From: Barber, Robert [REDACTED]
Sent: 15 October 2014 11:20
To: Neil Crowther
Cc: Michael Winterbottom [REDACTED]
Subject: RE: FP/136/14/A

From: Neil Crowther
Sent: 08 October 2014 15:22
To: [REDACTED]
Cc: Robert Barber [REDACTED]
Subject: FP/136/14/A

Drg No: PLAN-SALES/PH4-5/130912 Rev: C

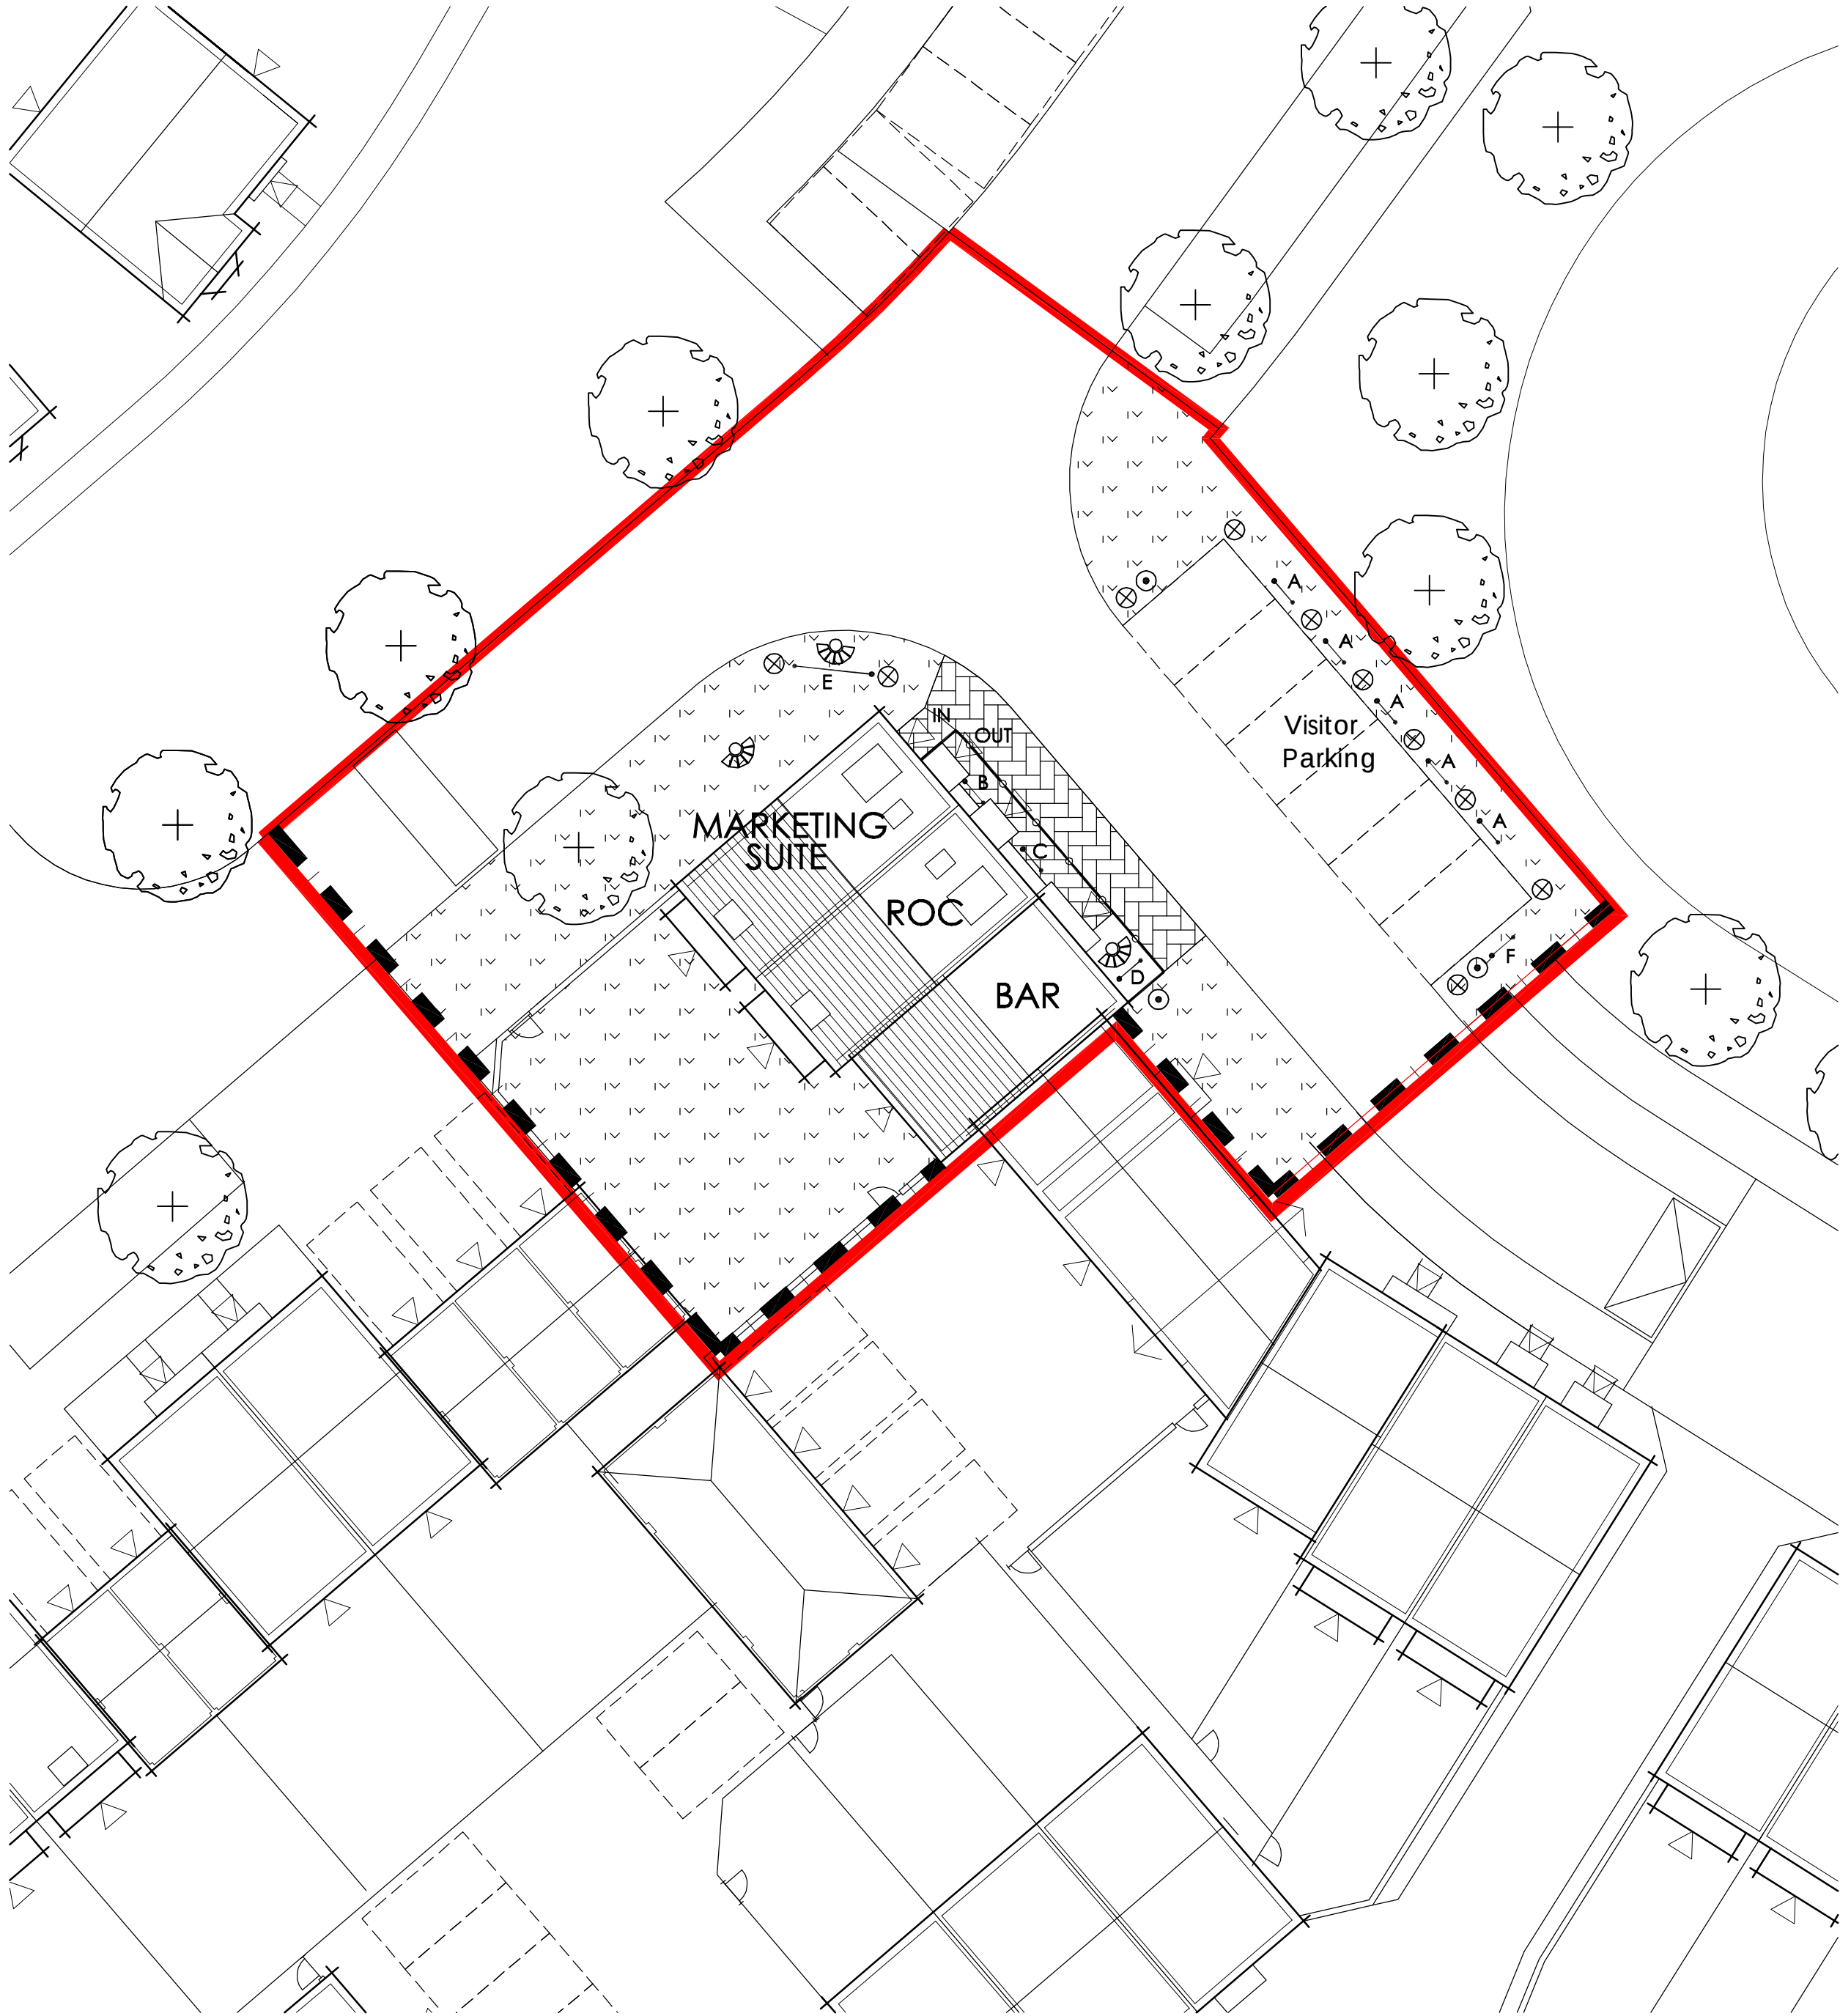
From the details submitted, I am unable to identify which adverts you are applying for and which are to be illuminated. Looking at the information, I don't think that we should have validated it because it cannot be understood.

Your drawing refers to advertisements A–F but there is no drawing indicating what advertisements A–F are. Please can you supply details of what advertisements A-F are (you can refer to the signage toolkit to highlight which signs are proposed from there) and indicate which of these advertisements are proposed to be illuminated.

Neil,
Further to your recent email, see attached signage plans which have been marked up to show additional information on proposed signage at our St Mary's site.

I am producing a detailed mark-up which will show additional information in regard to positioning / specification of signs. I am looking at getting this back to Carlton Design today so they can get their drawings updated.
